An
Coimisiún
Pleanála

Direction
CD-020573-25
ABP-322078-25

The Commission decided to grant permission generally in accordance with the Inspector's recommendation, for the following reasons and considerations, and subject to the following conditions.

DRAFT WORDING FOR ORDER

Drawing Title: FIGURE 5.04: ELECTRICITY SUBSTATION ENTRANCE DETAIL (1:400)

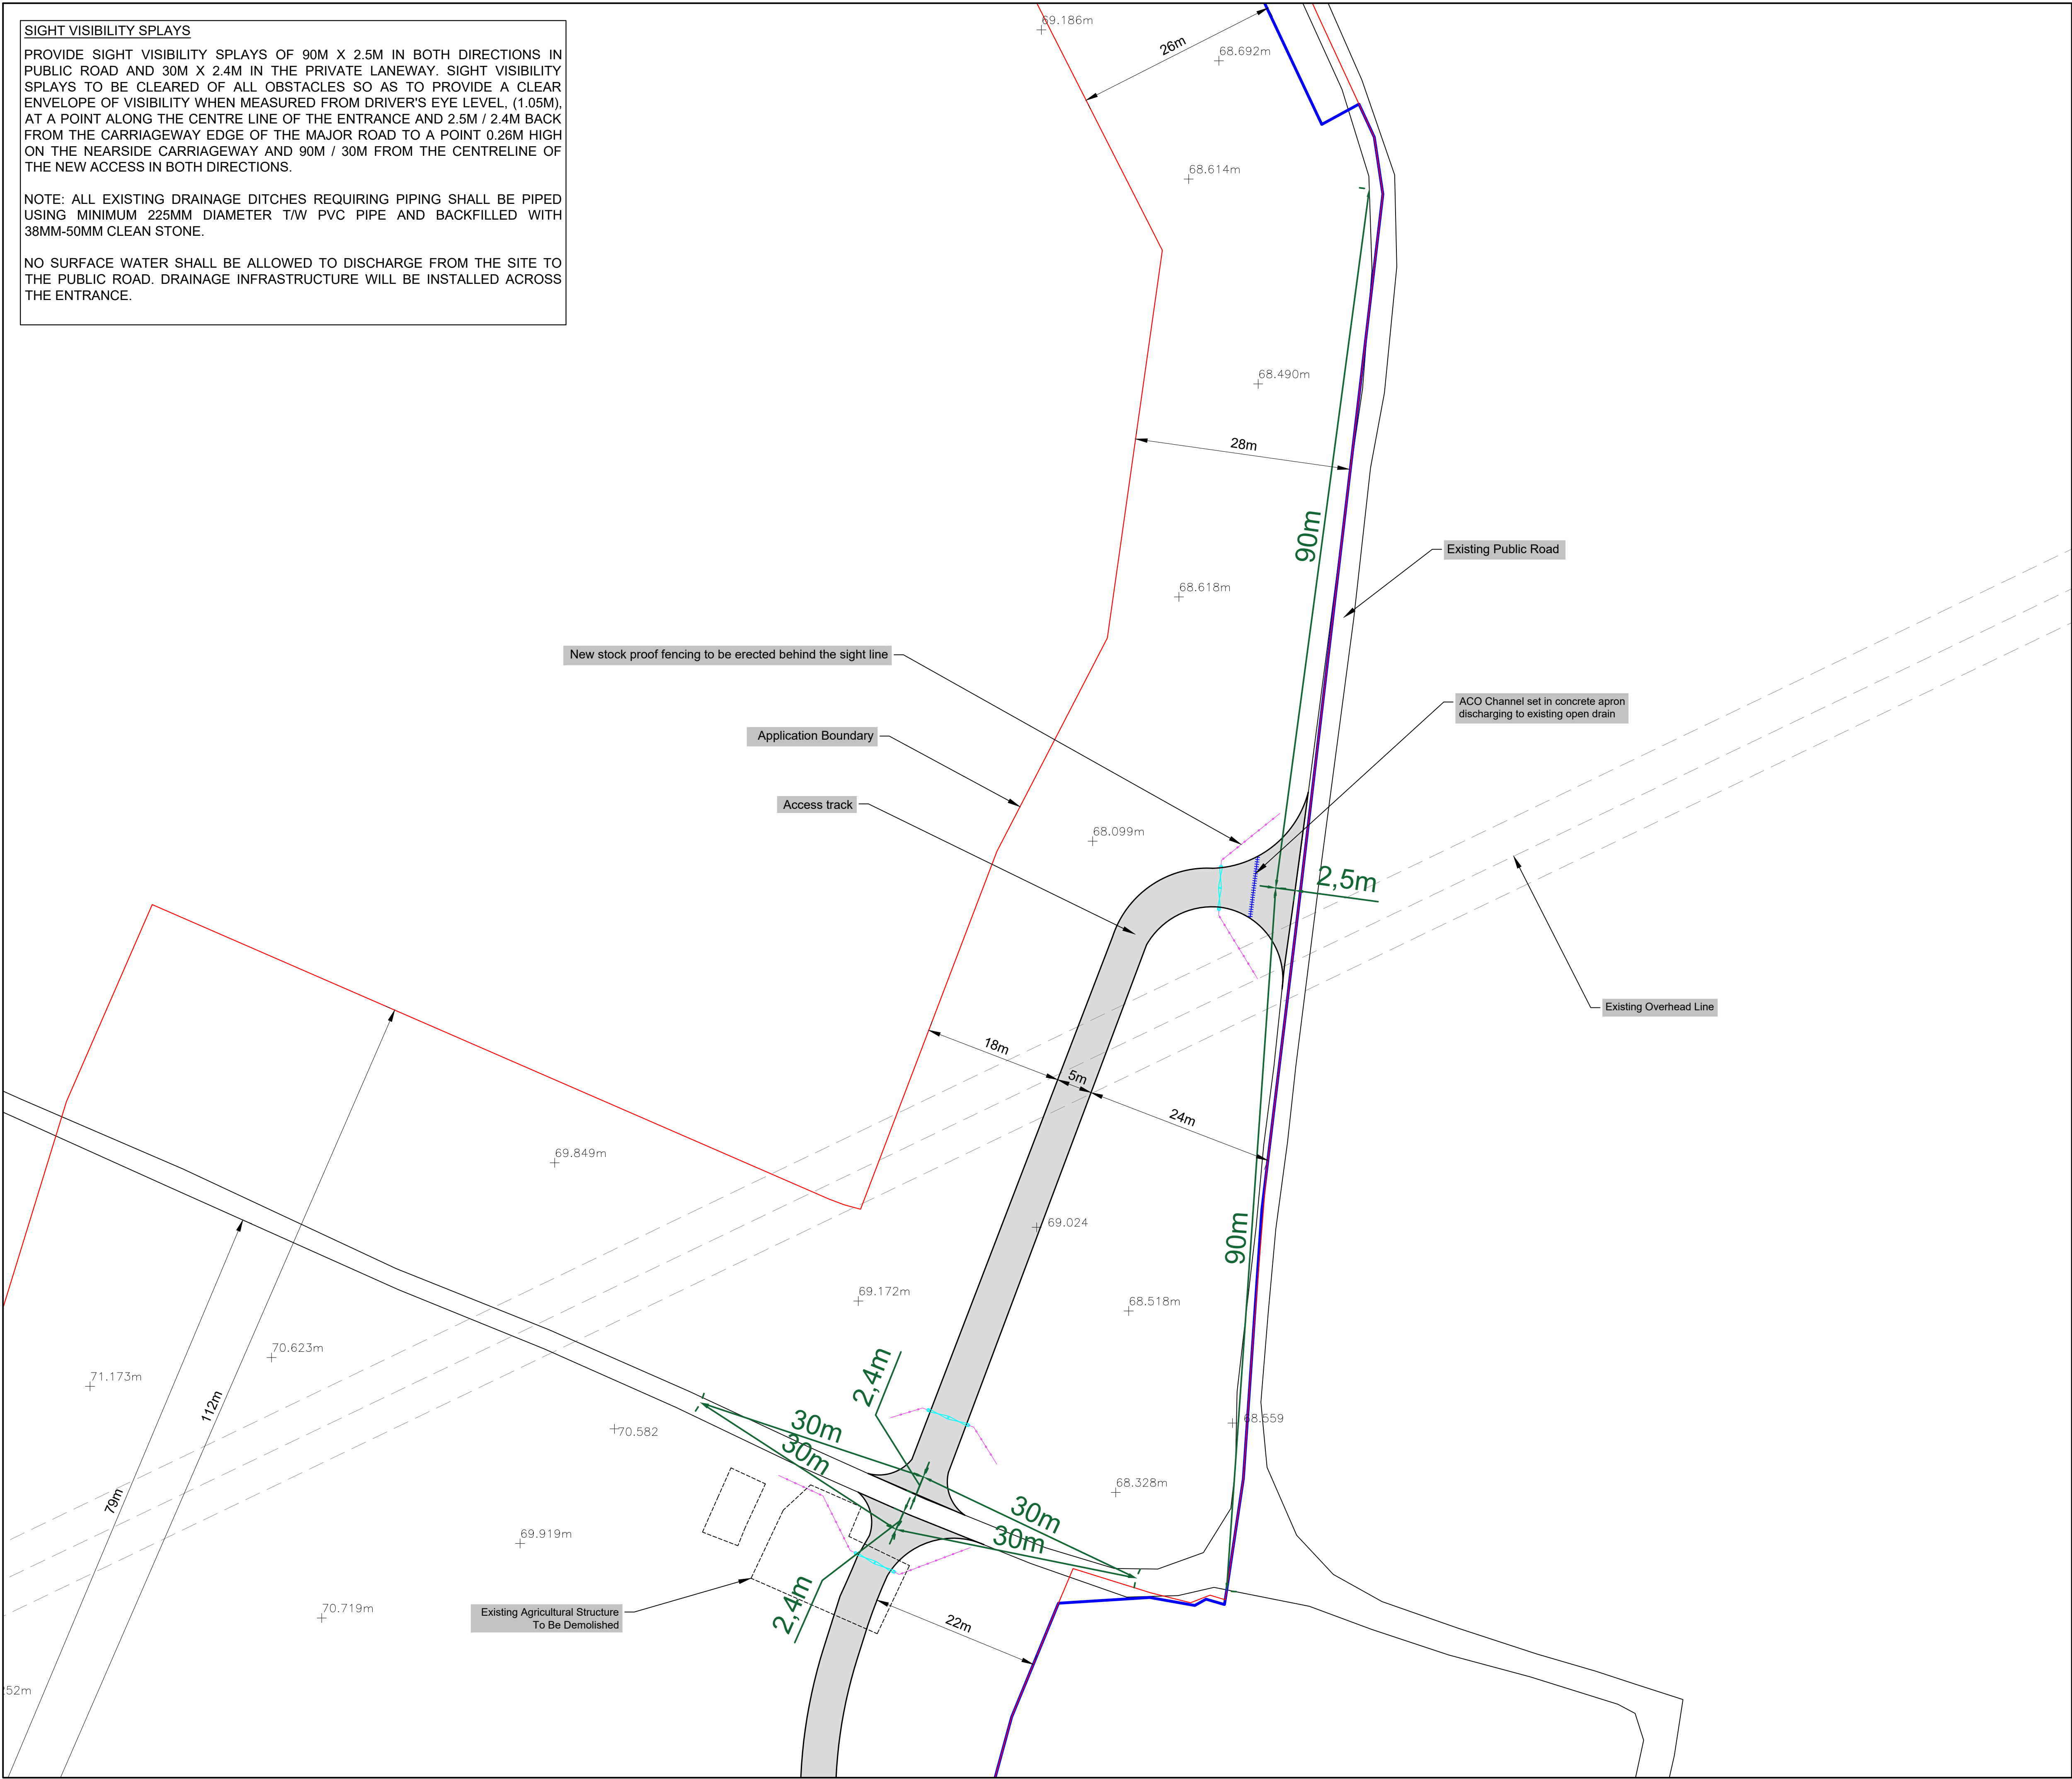
- (c) Surface water from the site shall not be permitted to drain onto the adjoining public road or adjoining properties.
- (d) The undertaker shall ensure that all soil and water quality related mitigation measures are implemented in full and monitored throughout the
